Current Zoning: I-2 (General Industrial)
Proposed Zoning: UR-2(CD) (Urban Residential, Conditional), MUDD(CD) (Mixed Use Development District, Conditional)

Approximately 7.41 acres located on the north side of W Trade Street near the intersection with Wells Meadow Drive.

The petition proposes to redevelop a site currently occupied by a childcare center with up to 116 single family attached residential dwellings and 12,000 square feet of non-residential uses.

SHEET NUMBER **RZ-02**

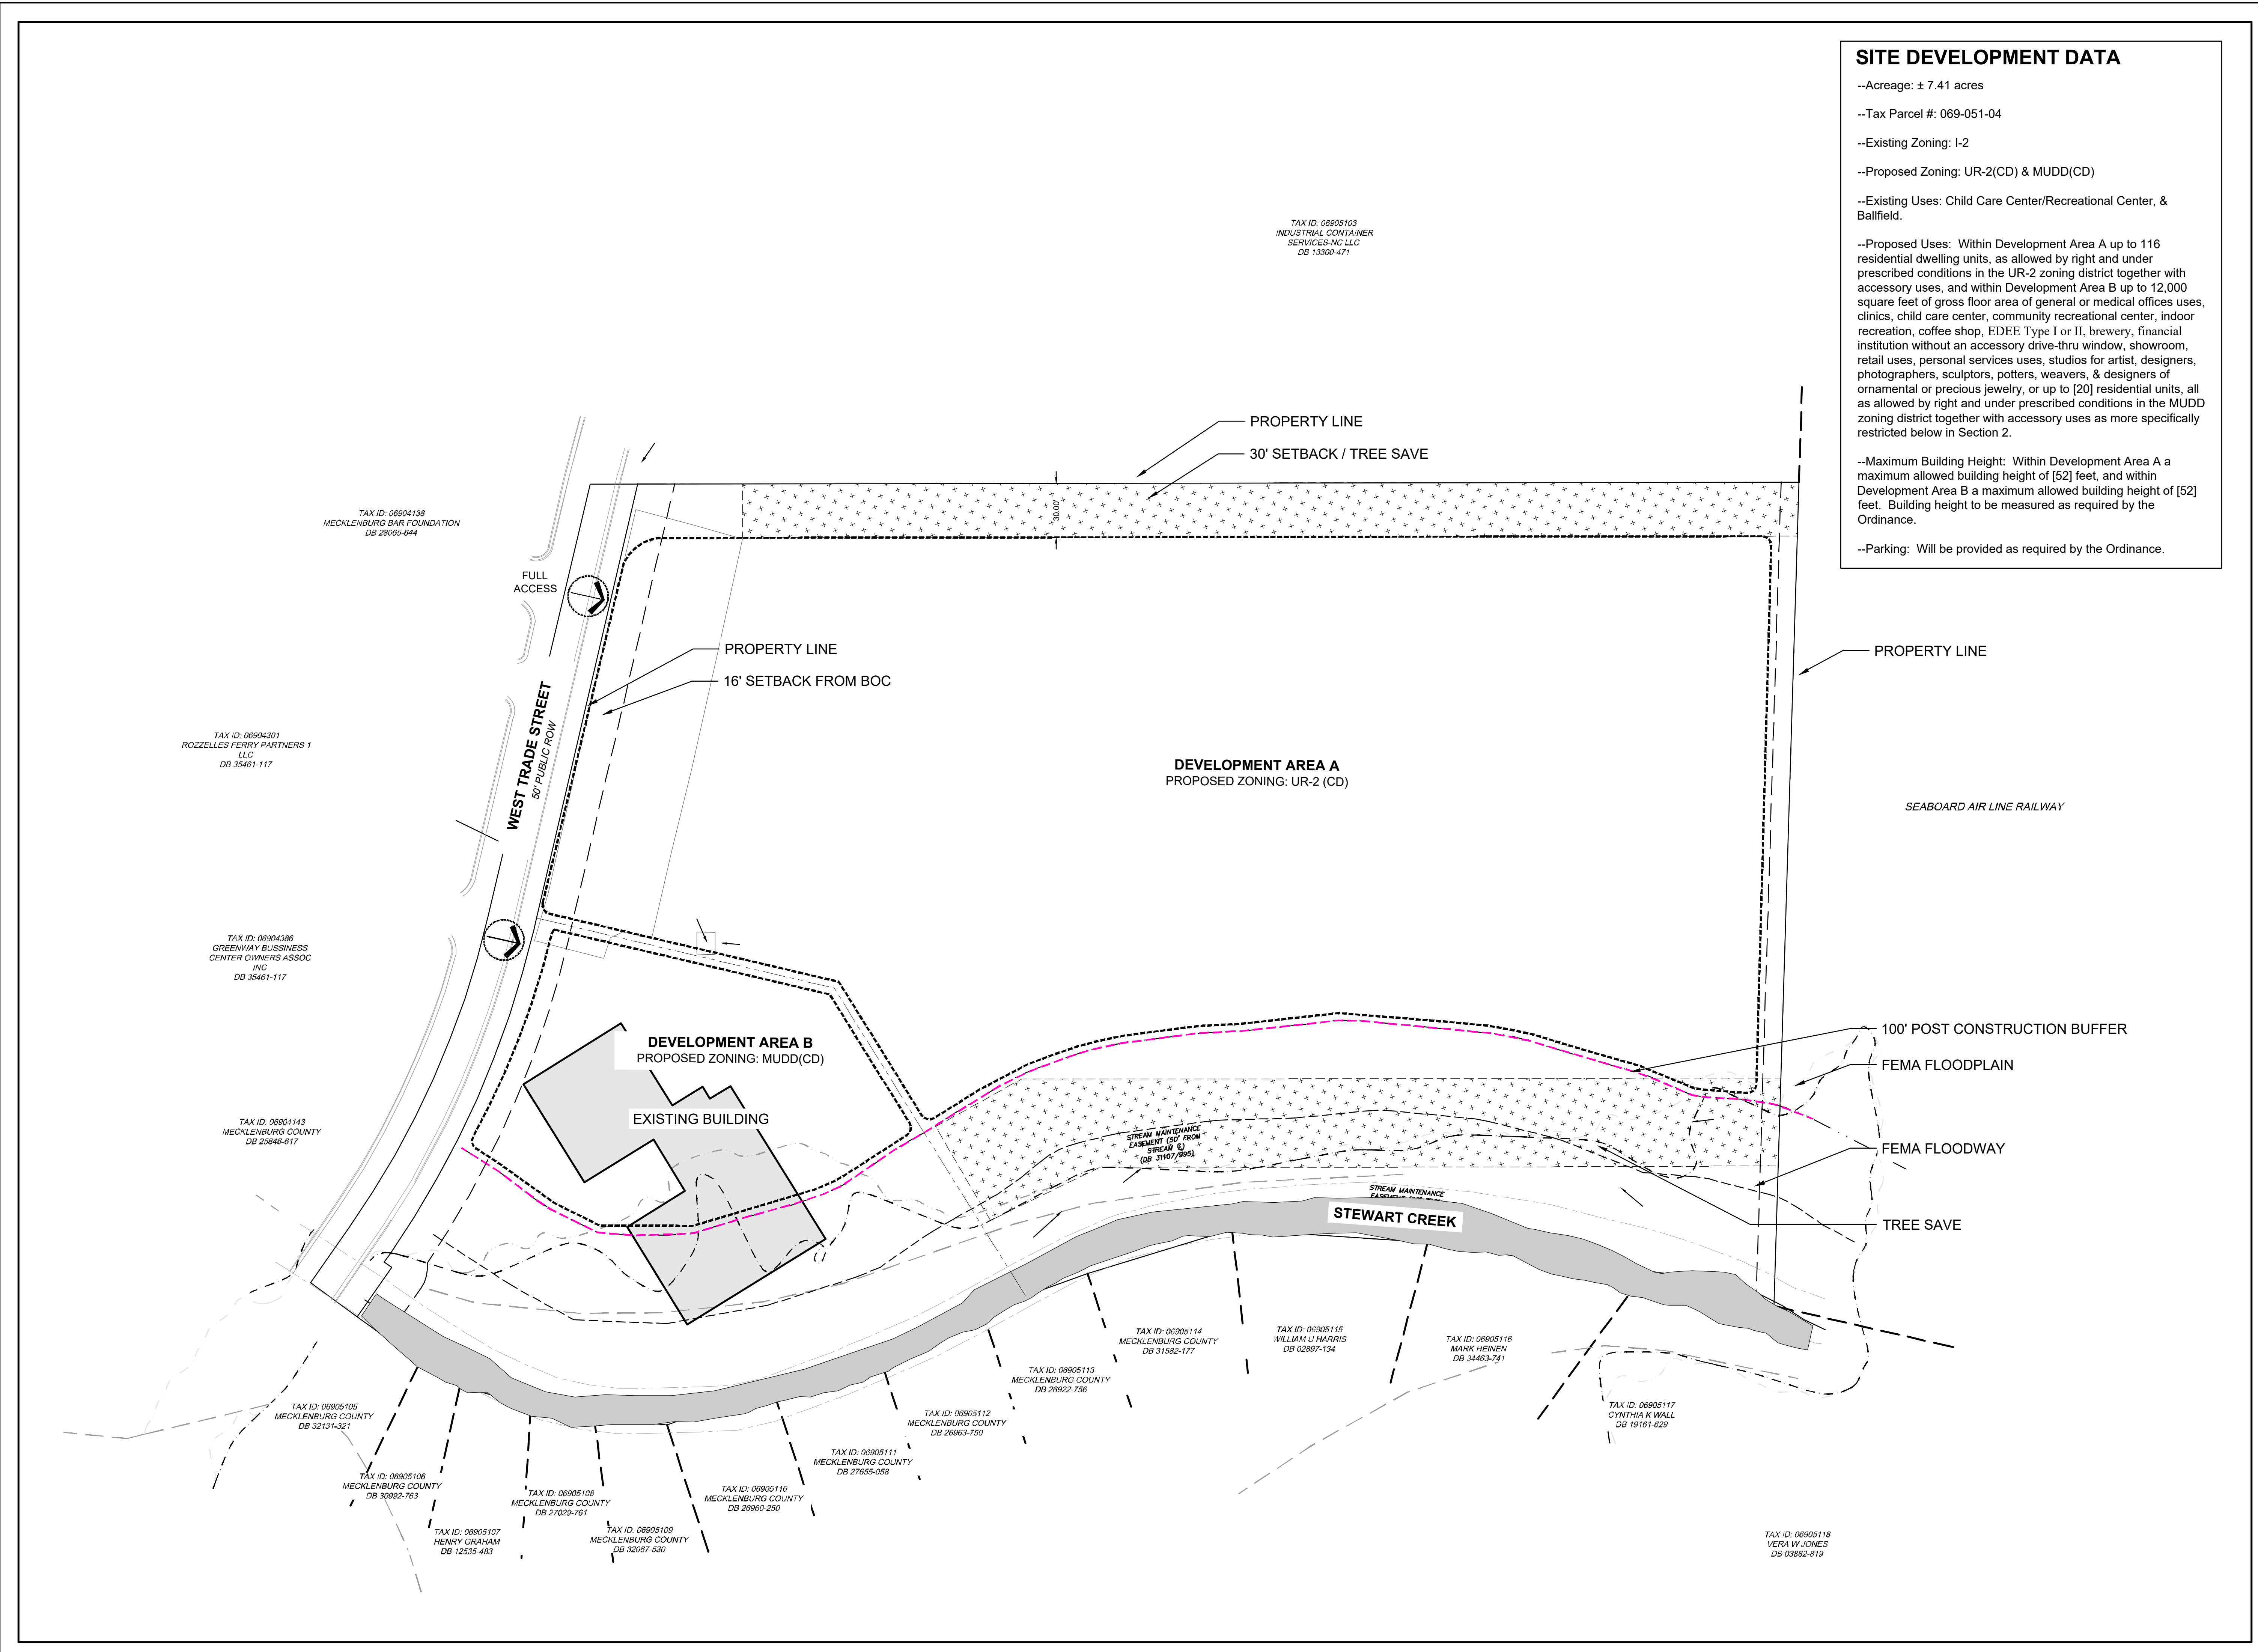
1. ~~Revise the site plan to show a 100' greenway easement dedication except where the building is located within the SWIM buffer.~~
2. ~~Revise the site plan to include an easement between the 100' greenway easement and internal sidewalk network.~~
3. ~~Wrap internal sidewalk around the northeastern most building to improve connection to open space.~~
4. ~~Remove note 4.c regarding side and rear yards.~~
5. ~~Clarify note 7.a regarding the provision of urban common open space and private open space.~~

-
- ~~6. Clarify note 5.c regarding the front elevation of each dwelling unit.~~
 - ~~7. Commit to preserving a minimum of 25' 30' along the western property boundary as tree save or label as a 25' Class A buffer. Tree save must be a minimum of 30' in width. OUTSTANDING~~
 - ~~8. Reword note 2.b to state that Development Area B may include up to 12,000 square feet of gross floor area of noted uses within the existing building.~~
 - ~~9. Reword note 2.c to state that any Type II EDEE use must serve food.~~
 - Environment
 - ~~10. Provide a tree survey identifying all trees of eight inch DBH or greater and all planted trees of two inch or greater and six feet in height that grow partially or wholly within the city right of way.~~
 - ~~11. Ensure that tree shown in right of way matches existing conditions. OUTSTANDING~~
-
